**KIRKLEES METROPOLITAN COUNCIL
INVESTMENT & REGENERATION SERVICE**

Reference No:	2022/62/90738/W
Site Address:	8, Oaklands Drive, Dalton, Huddersfield, HD5 8PR
Description:	Erection of two-storey side extension and associated alterations
Recommending Officer:	Hubert Lam

Officer Report

2022/90738 – 8 Oaklands Drive, Dalton, Huddersfield, HD5 8PR

PROPOSED FRONT ELEVATION

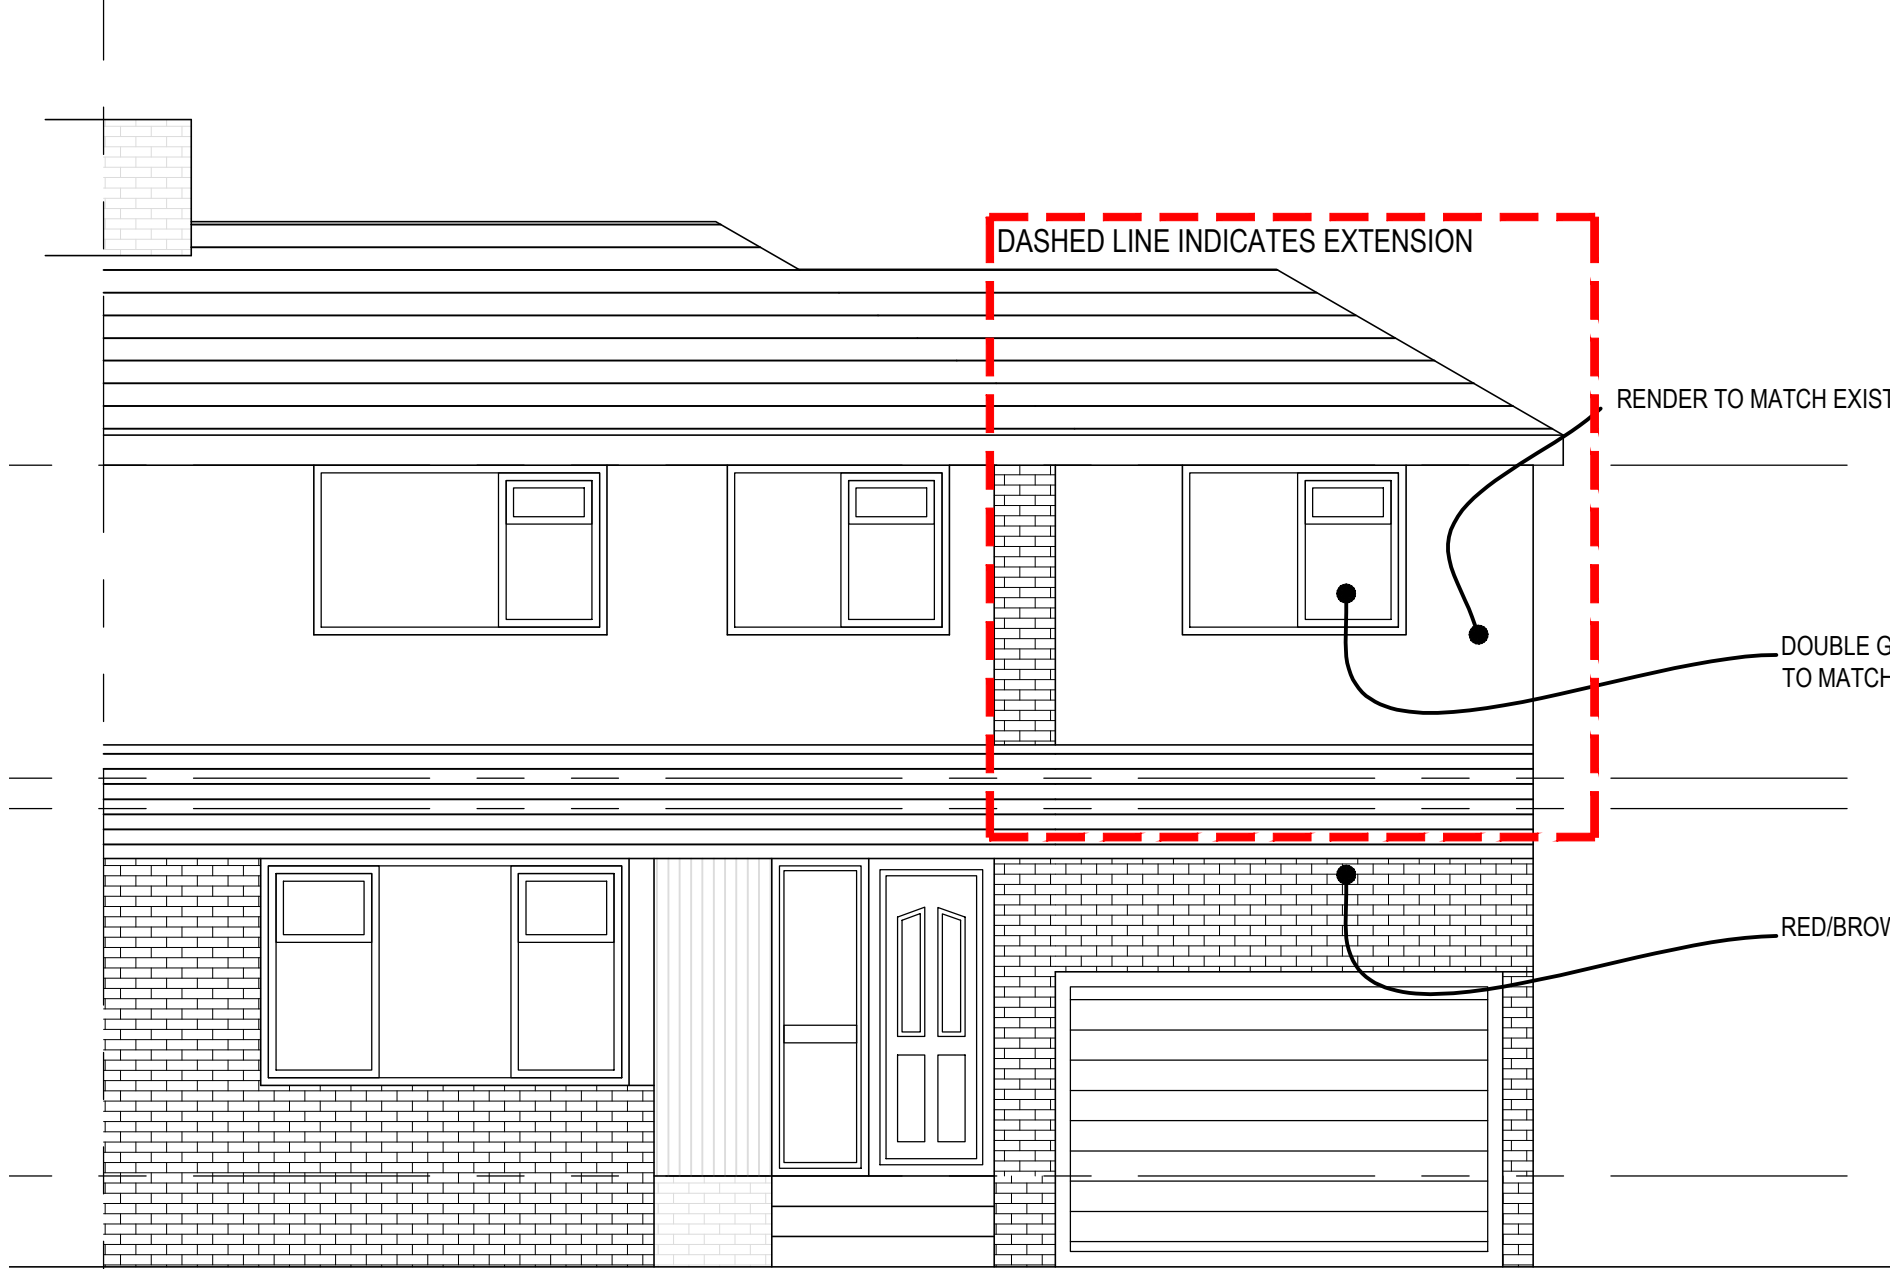
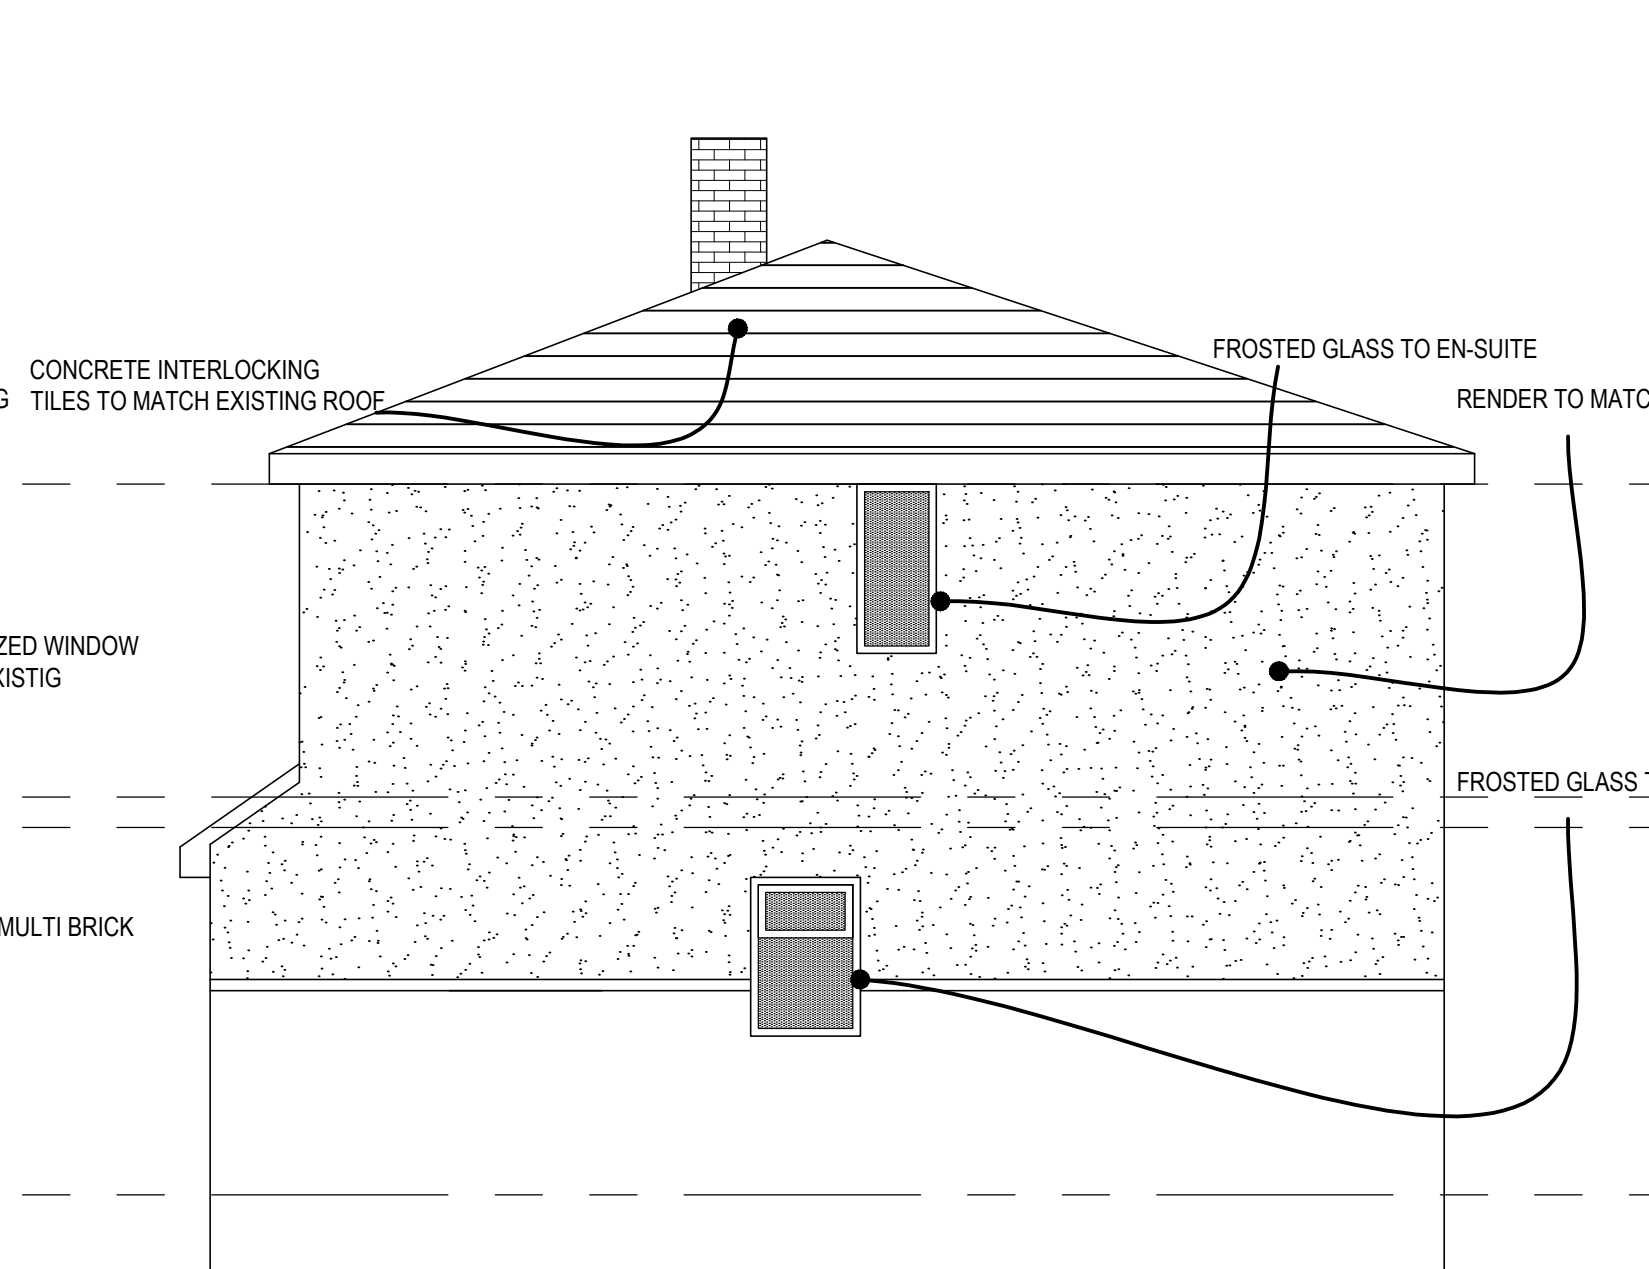
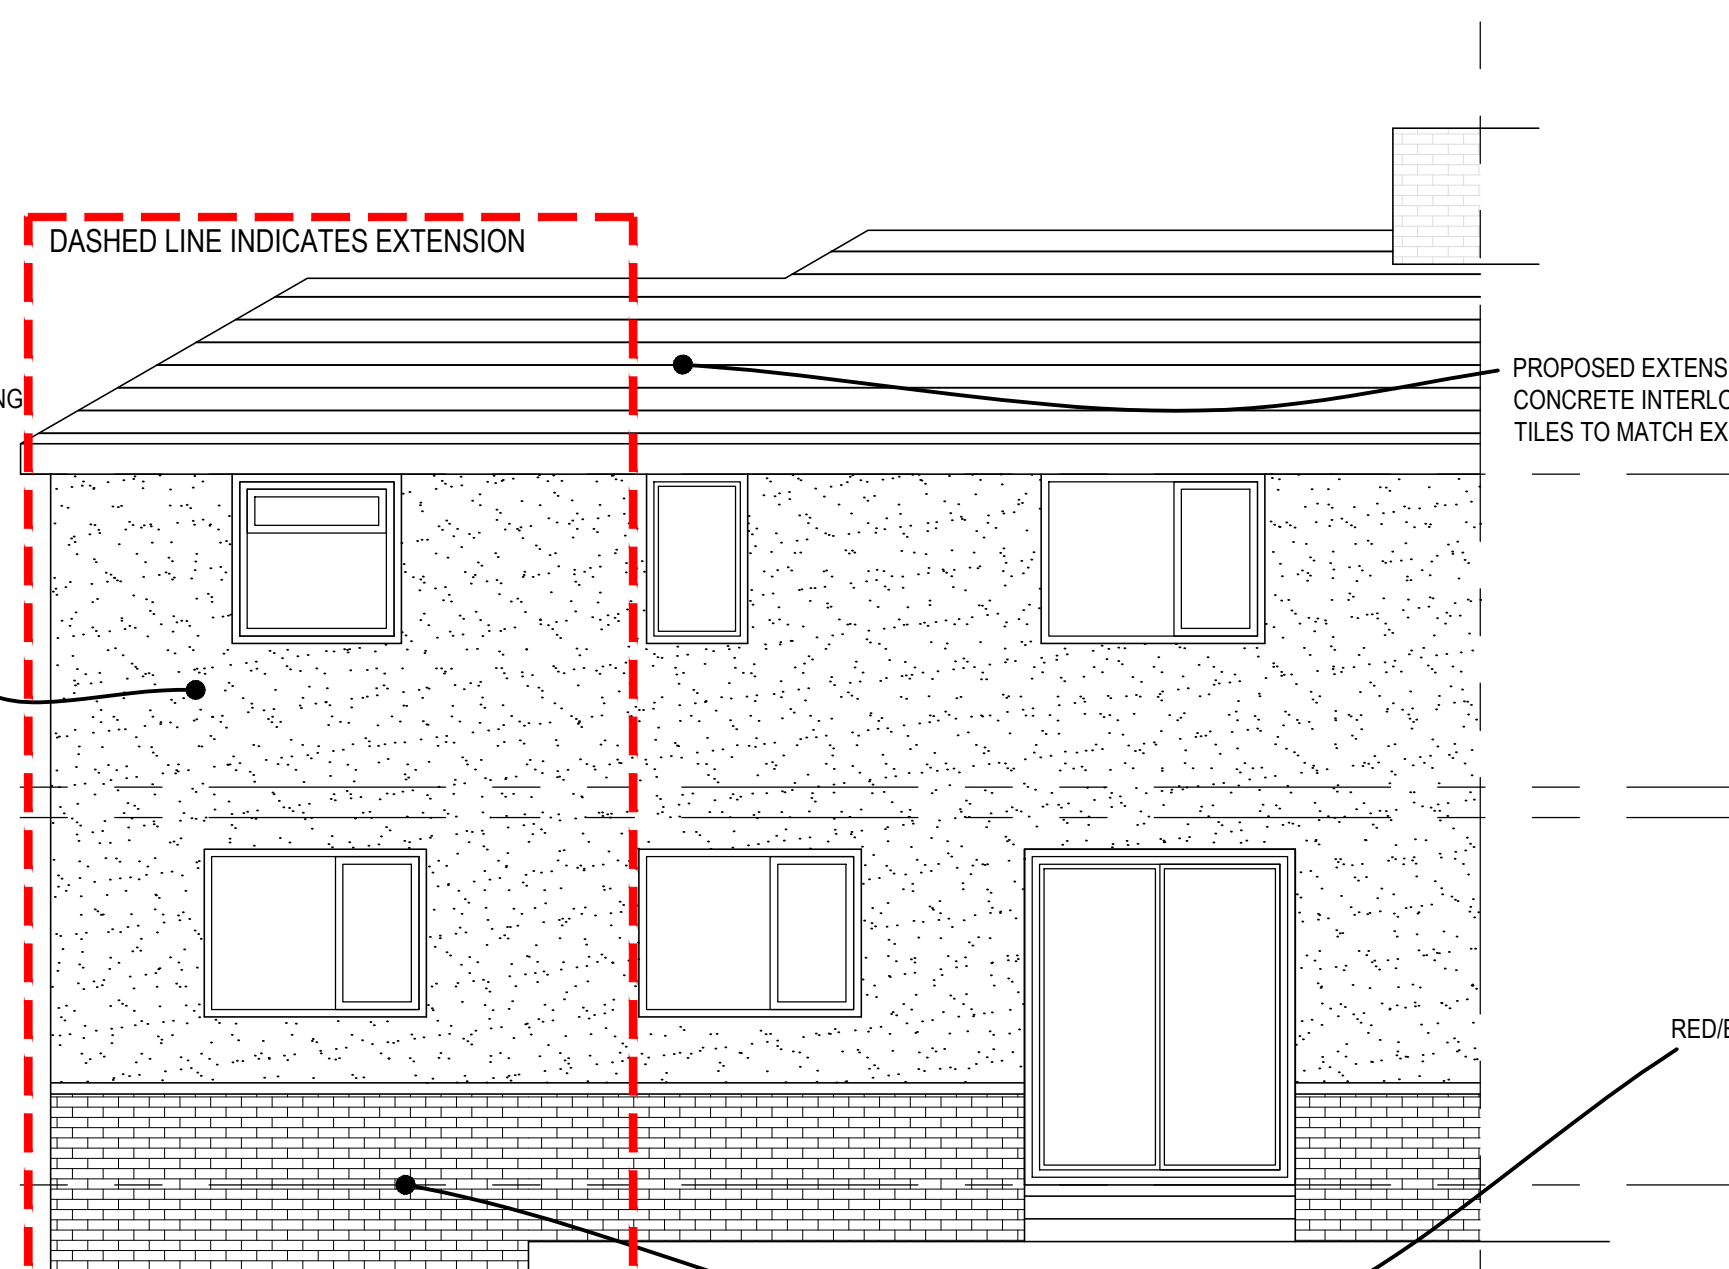
Whilst it is acknowledged that the proposed roof ridge would be stepped down from that of the existing building and would have a width roughly half of this dwelling, the front elevation would align with the existing front elevation of the main house and therefore the extension could not be said to be truly subservient to the main house. Whilst this is unfortunate, the neighbouring dwelling forming part of the same semi-detached building has been extended to its side by two storeys and this does not have a set back from the front elevation and has an eaves ridge height similar to that of the existing dwelling. In this context it is considered that it would be difficult to resist such an extension, especially given that it would be subordinate in width to the main dwelling and would incorporate the detailing of the existing house.

PROPOSED SIDE ELEVATION

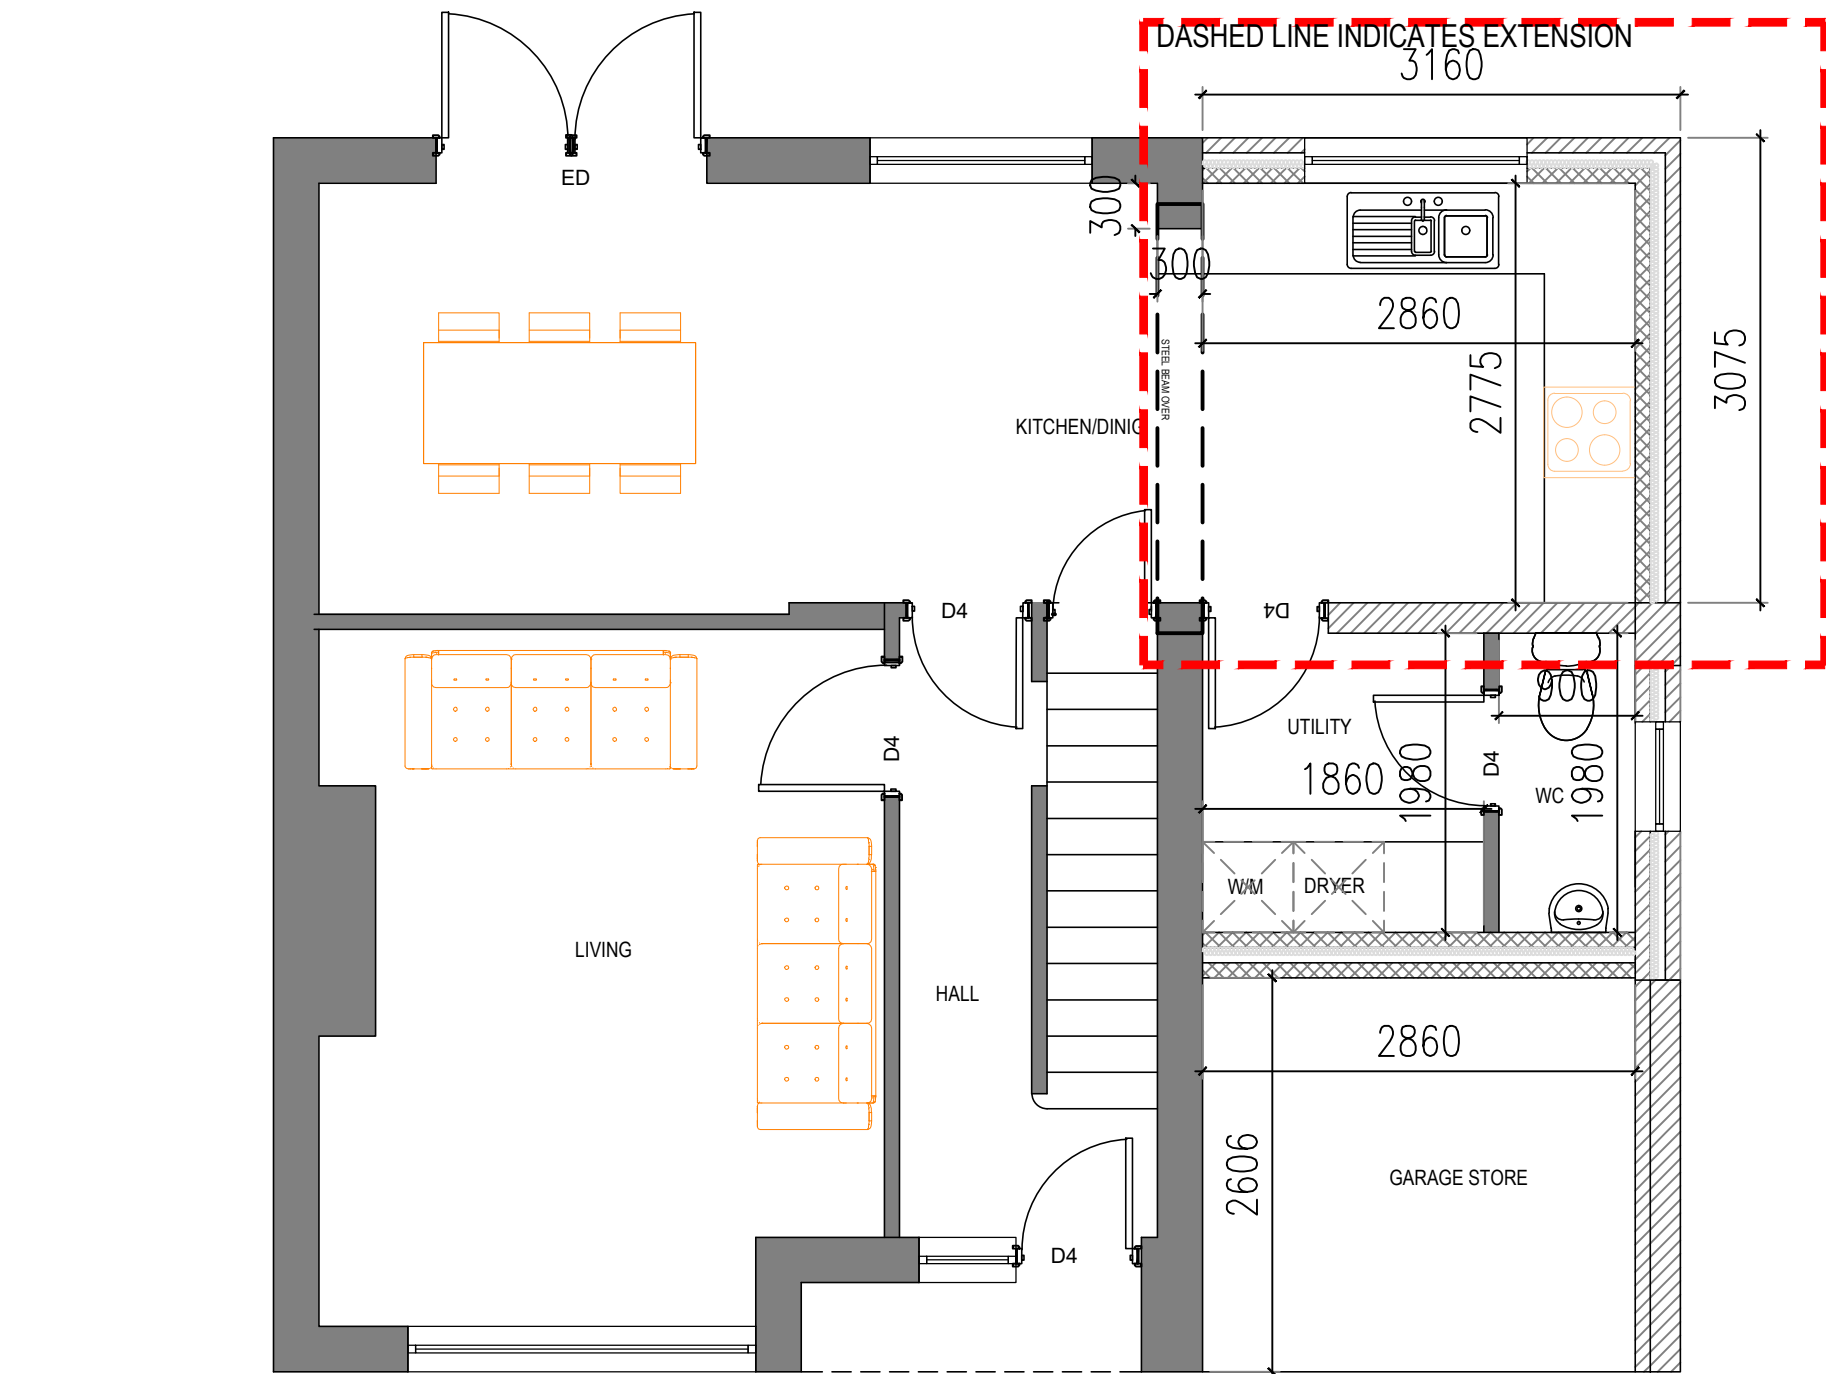
4. The proposed first floor window in the north east side elevation of the extension hereby approved shall be fixed shut unless parts of the window which can be opened are more than 1.7 metres above the floor of the room in which the window is installed, and obscurely glazed (Level 3 or above), and retained as such thereafter.
